MECKLENBURG COUNTY
Land Use & Environmental Services Agency

MEMORANDUM

Subject: Additional Ground Water Services Rezoning Petition Comments

2020-105: Saratoga Asset Management LLC

RZ-1.0

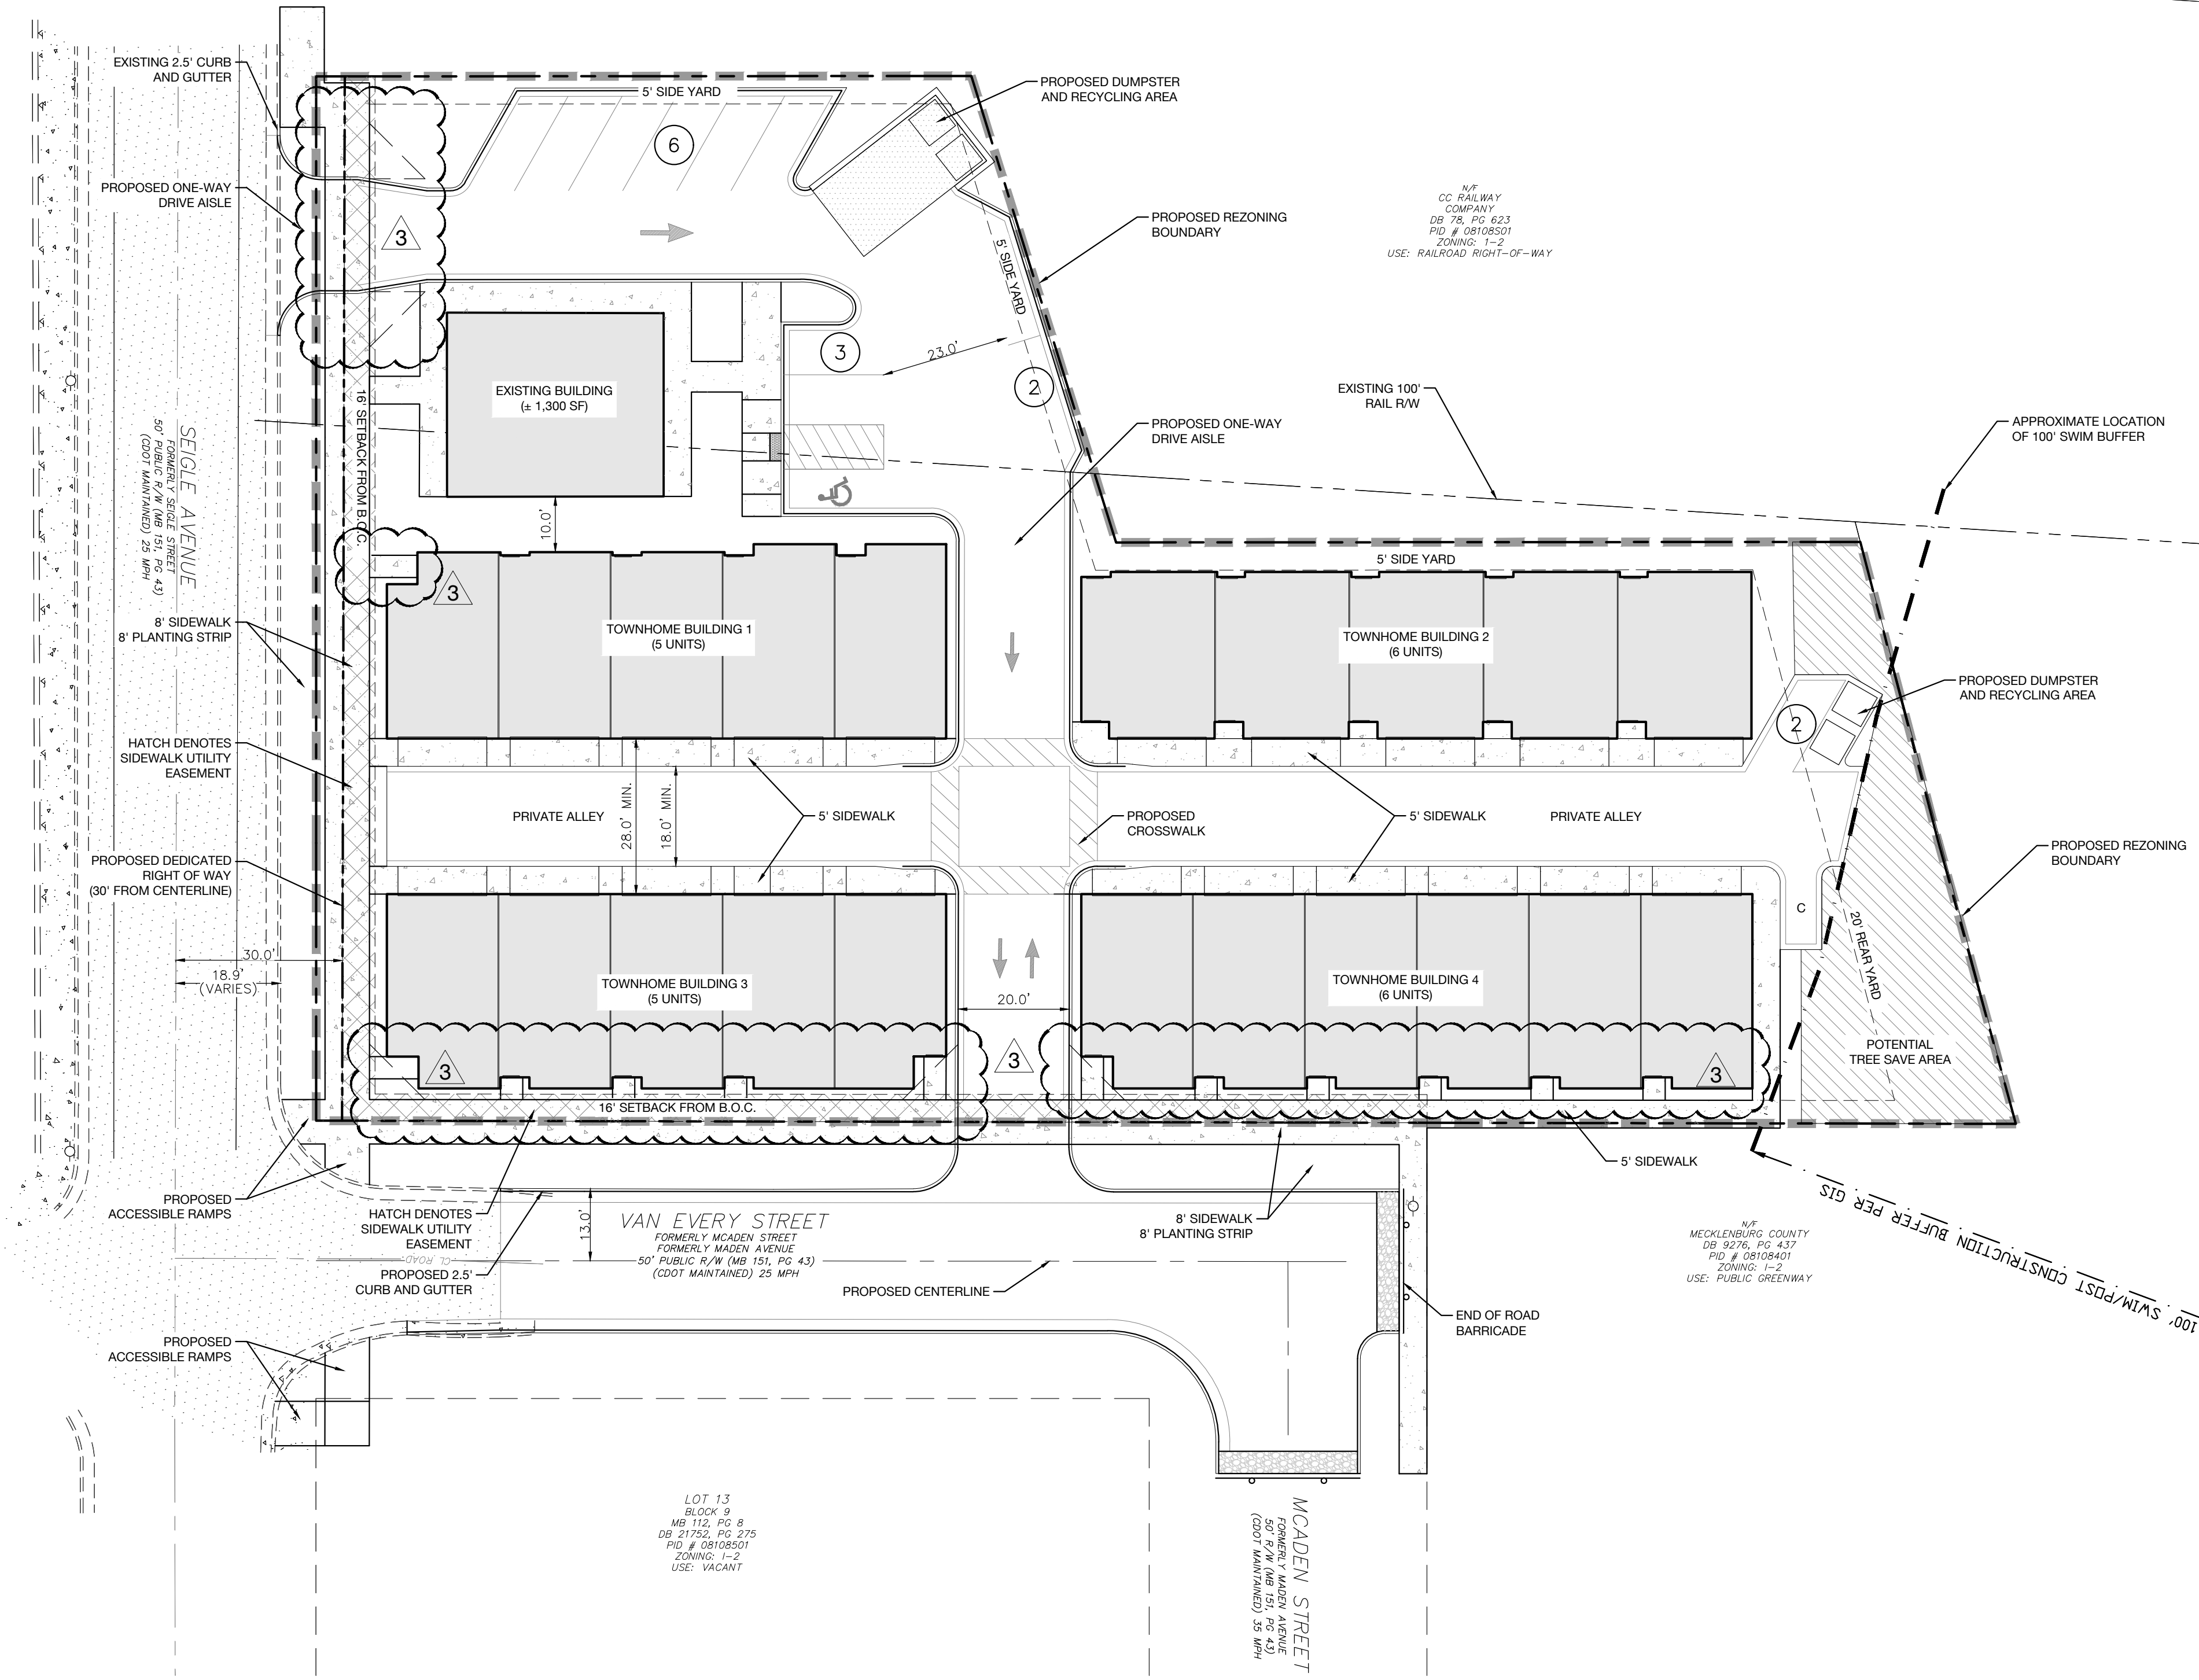
Groundwater & Wastewater Services records indicate a Subsurface Investigation Permit (SIP) was issued for parcel 081-084-15. Please note that monitoring wells on this parcel need to be located, flagged and

protected prior to development or be permanently abandoned in accordance with the Mecklenburg County Groundwater Well Regulations.
